Adams School Redevelopment

Addendum No. 5 to Contract Documents

April 19, 2012

SHEET
S1.2

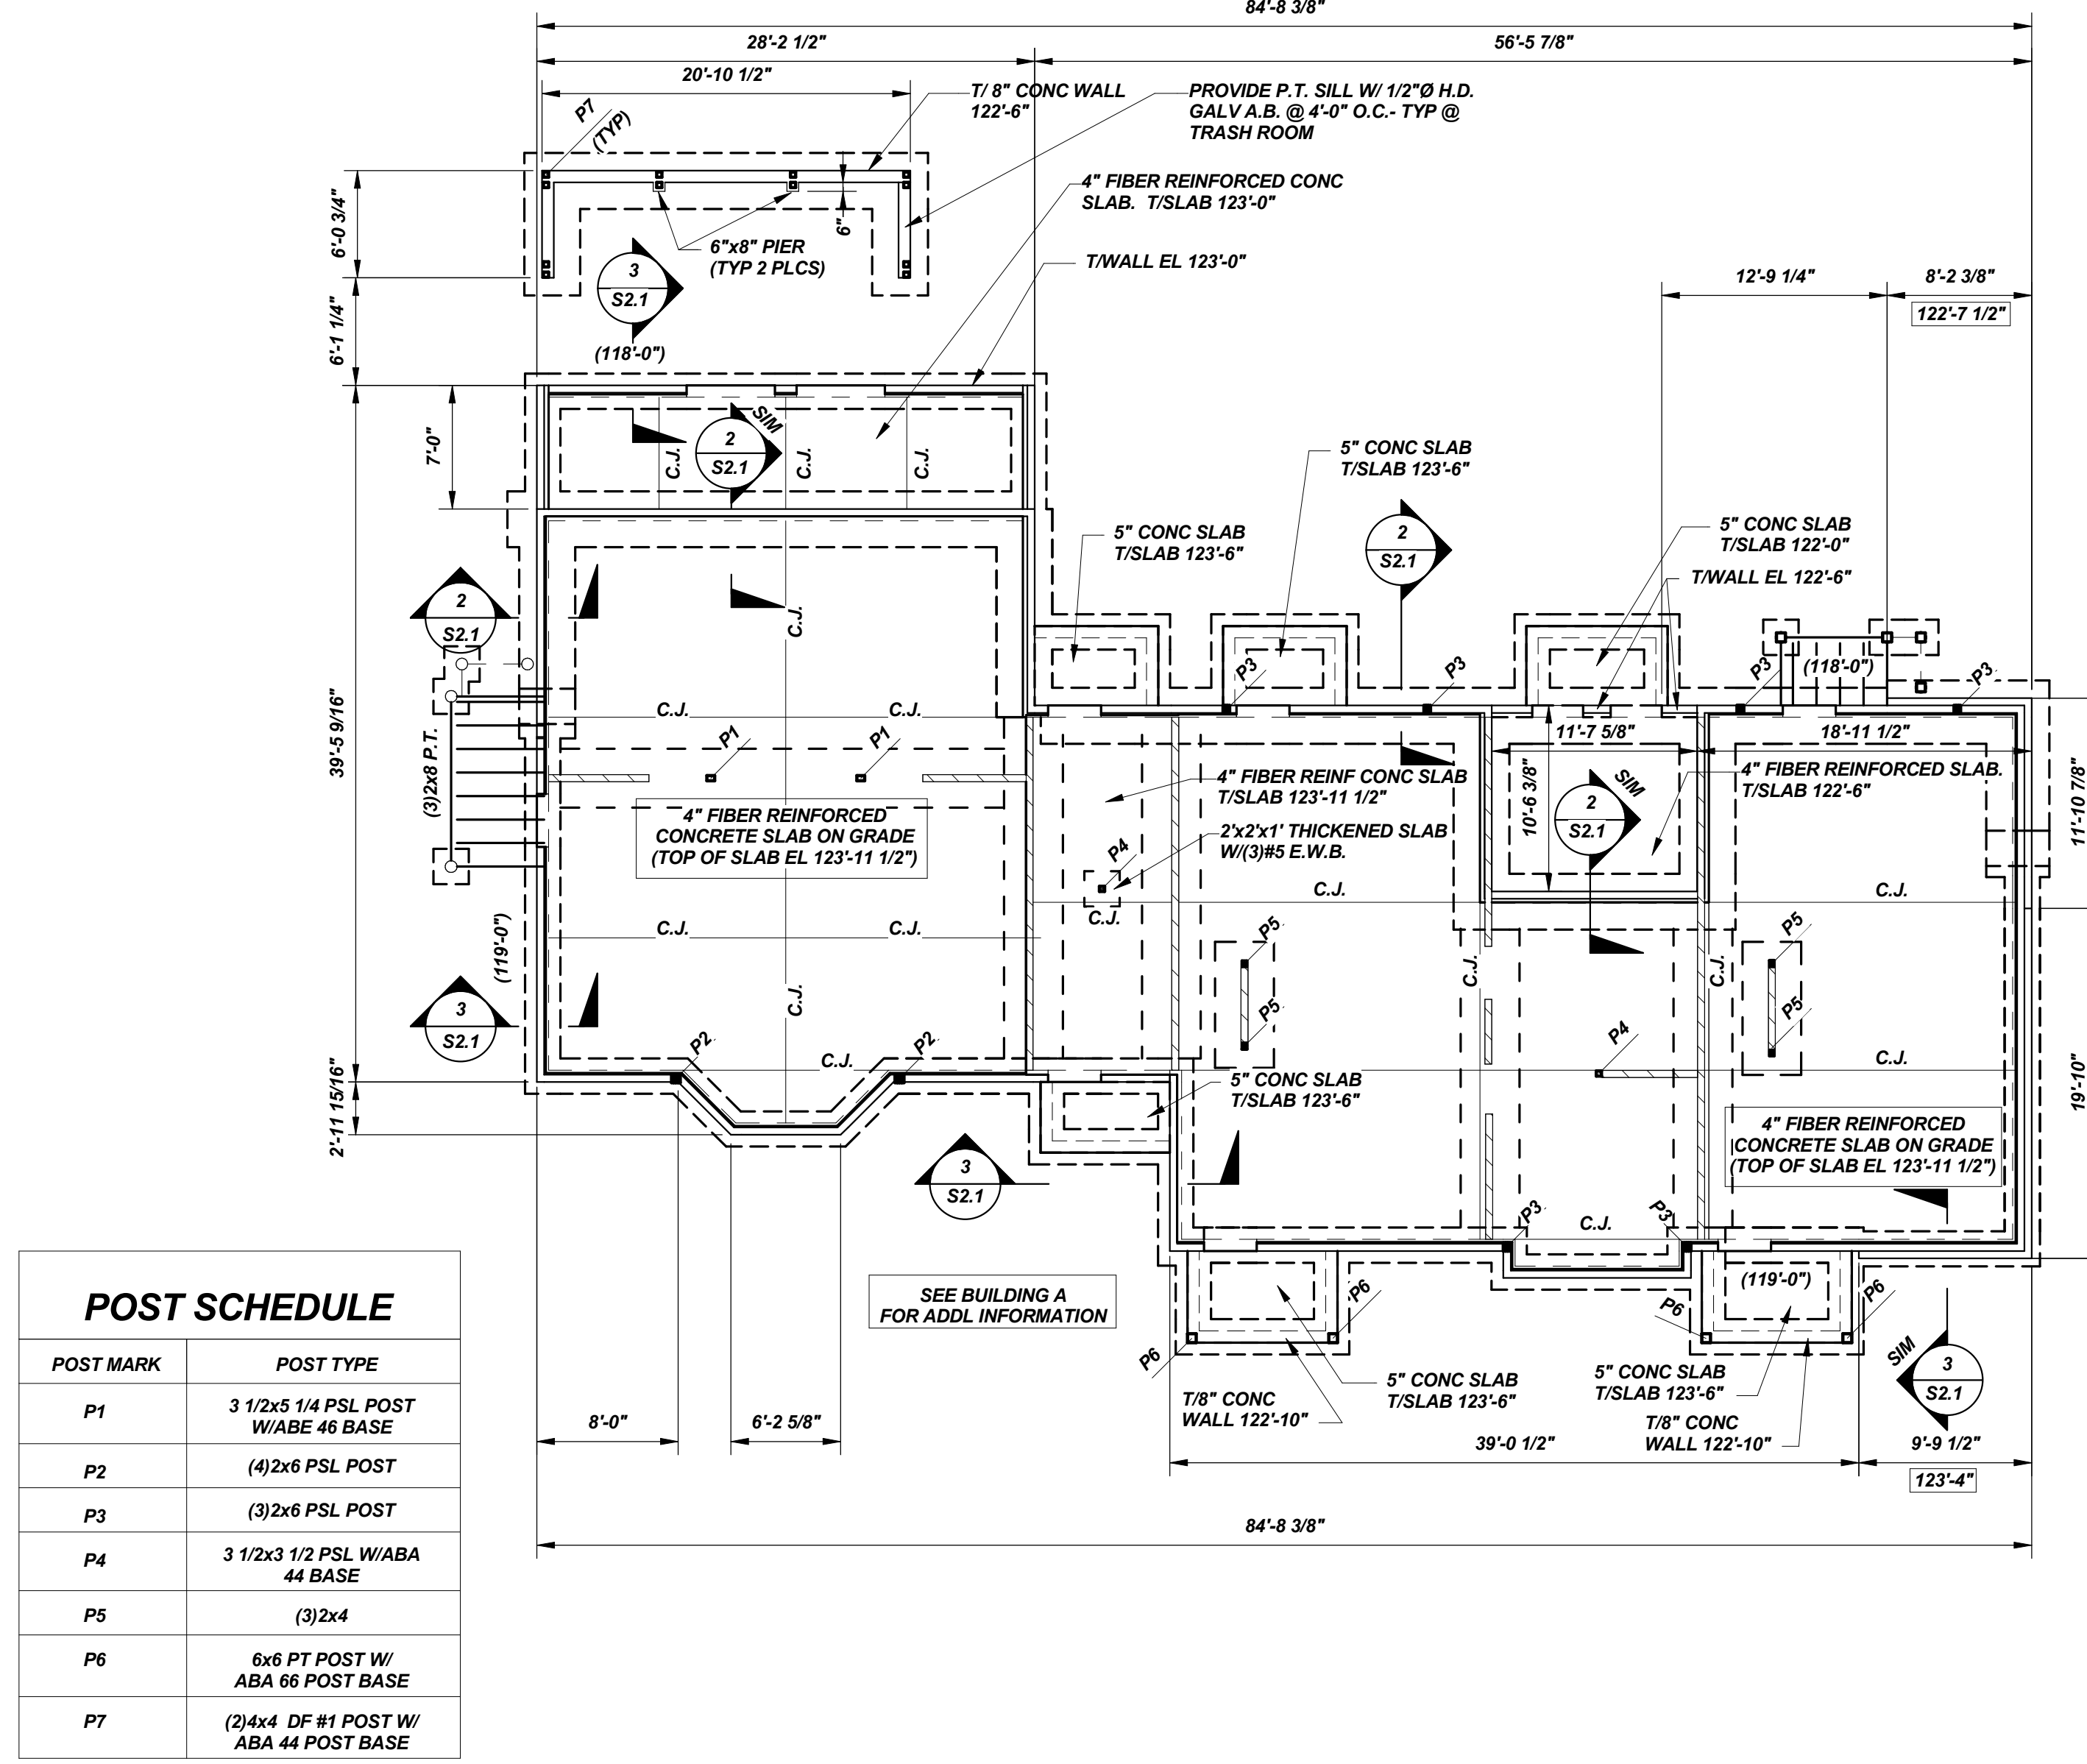
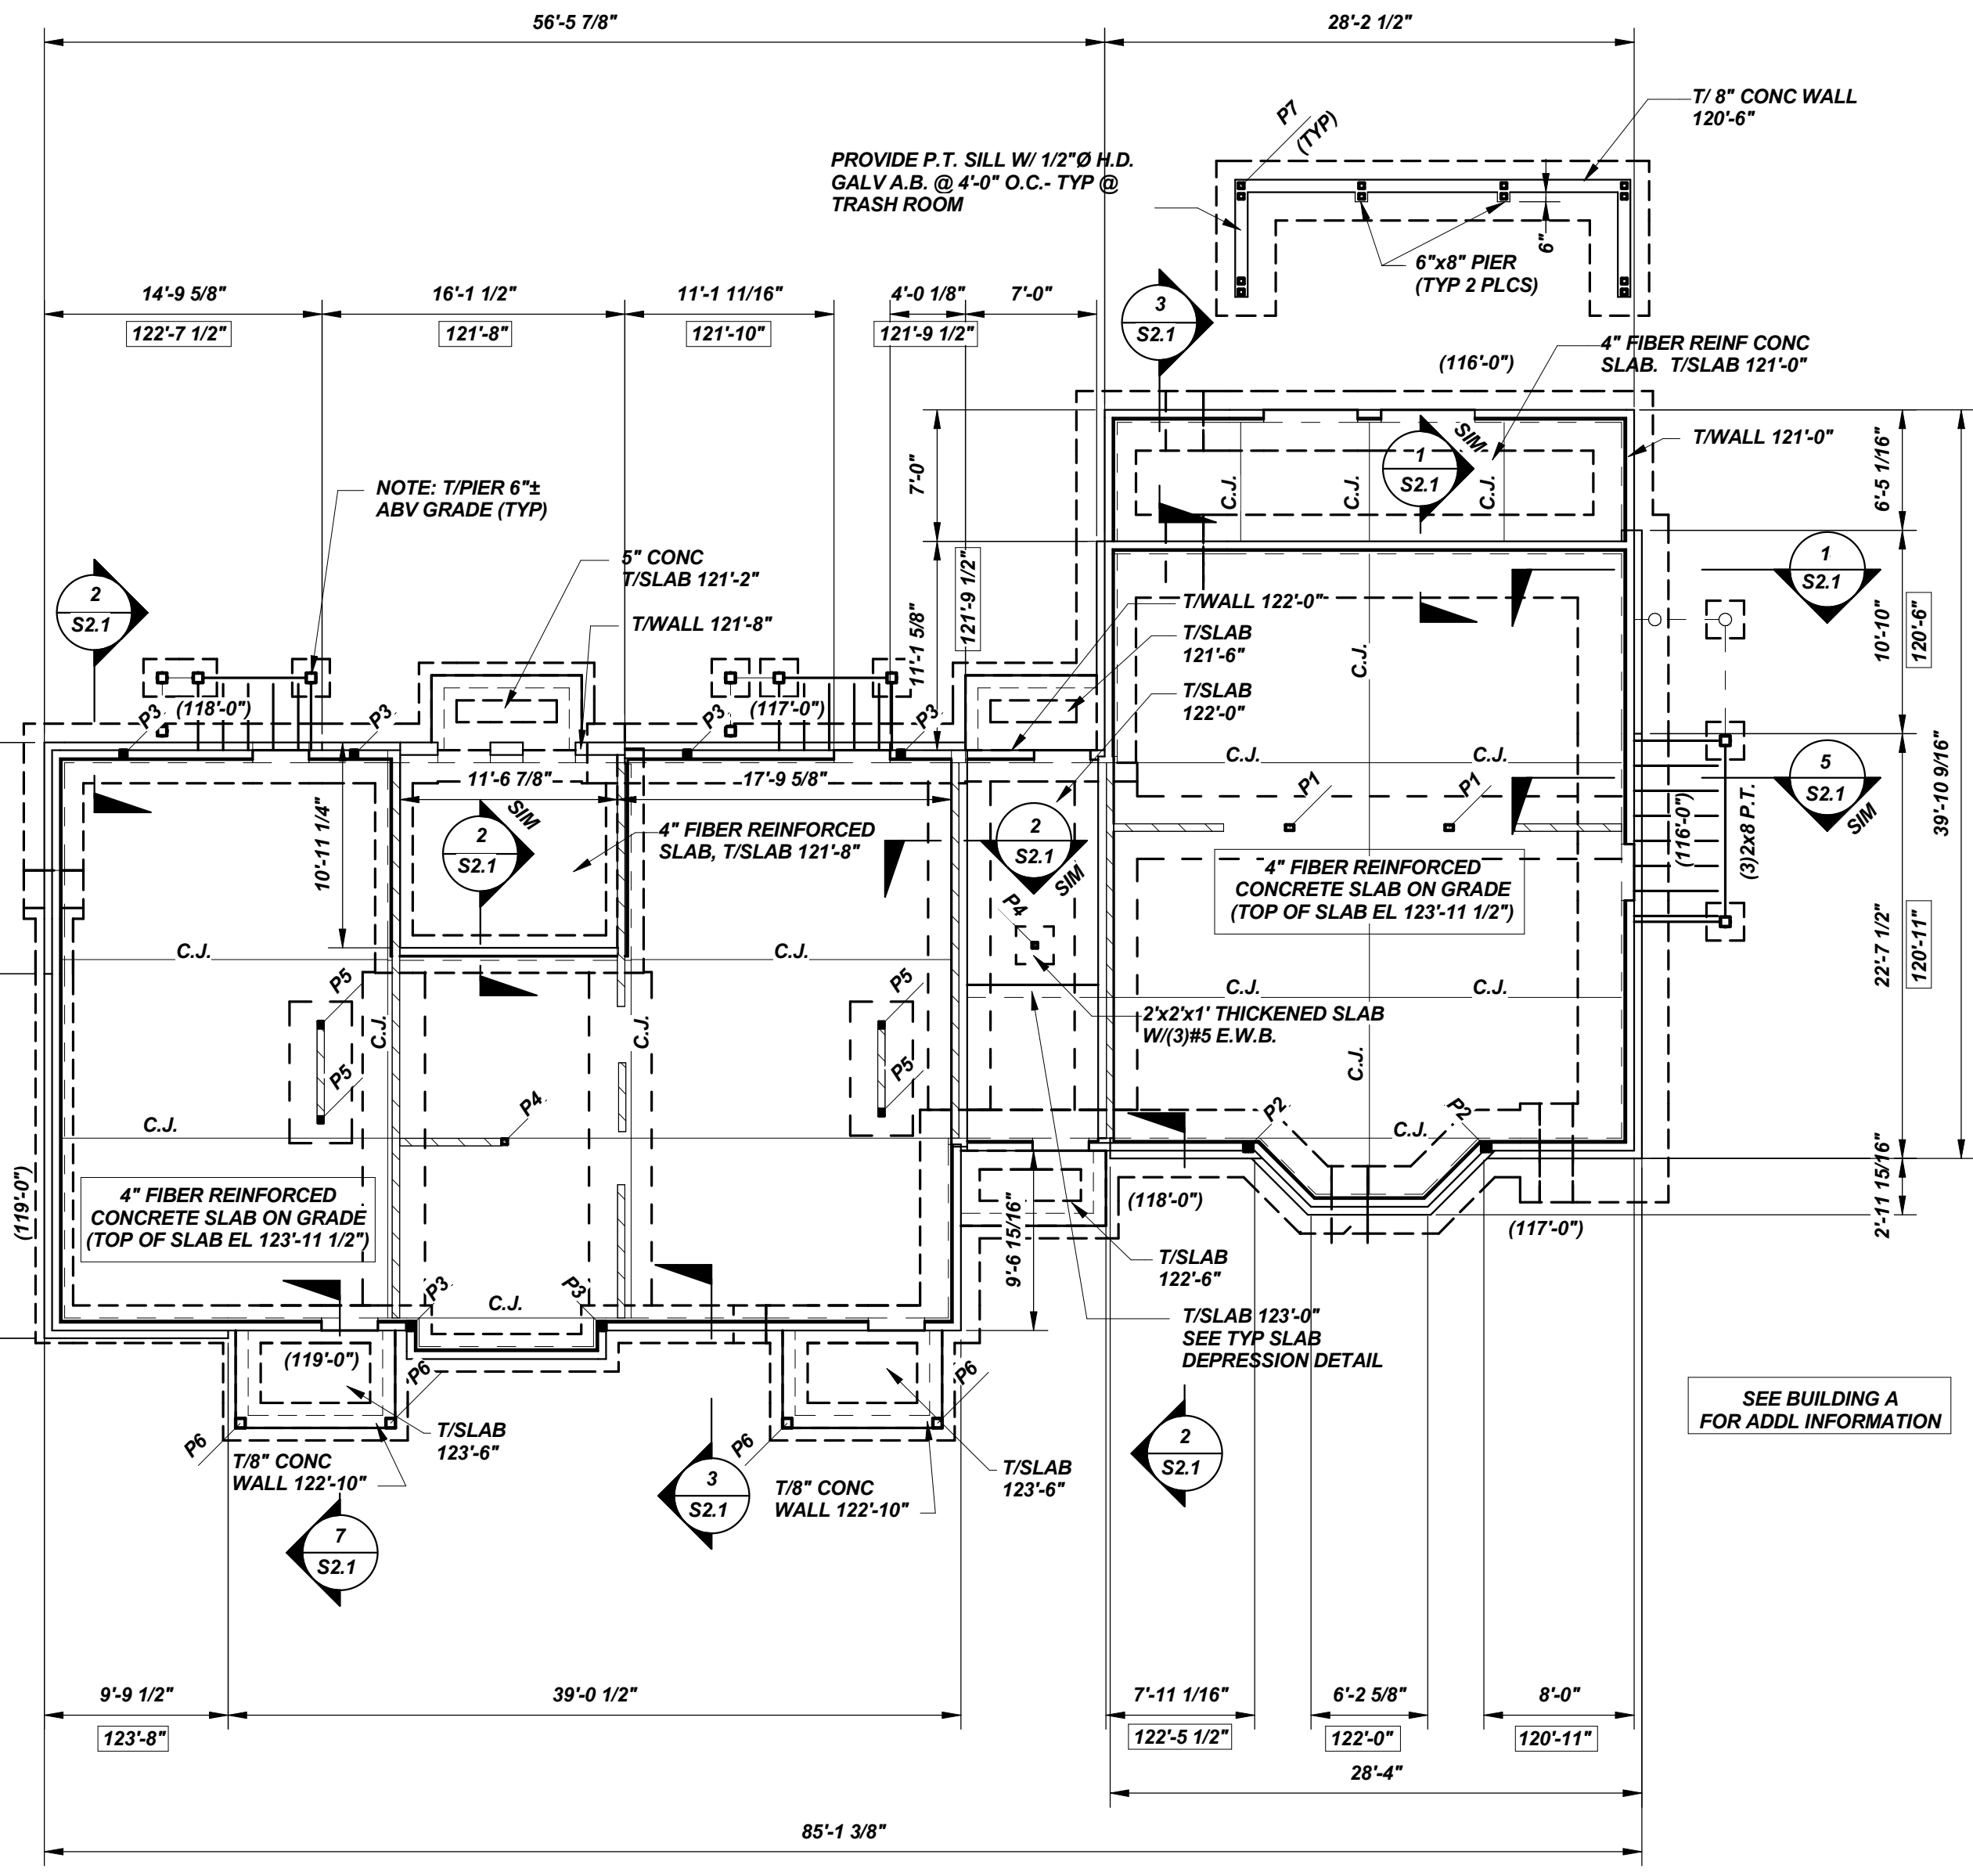
- A. Sheet S1.1: Modify as shown in attached sketch SKS-2/Addendum 5.
- B. Sheet S1.2: Modify as shown in attached sketch SKS-2/Addendum 5.

SKS-2 4/19/12
REVISIONS TO EXT. SLAB DIMENSIONS
PAGE 2 OF 2
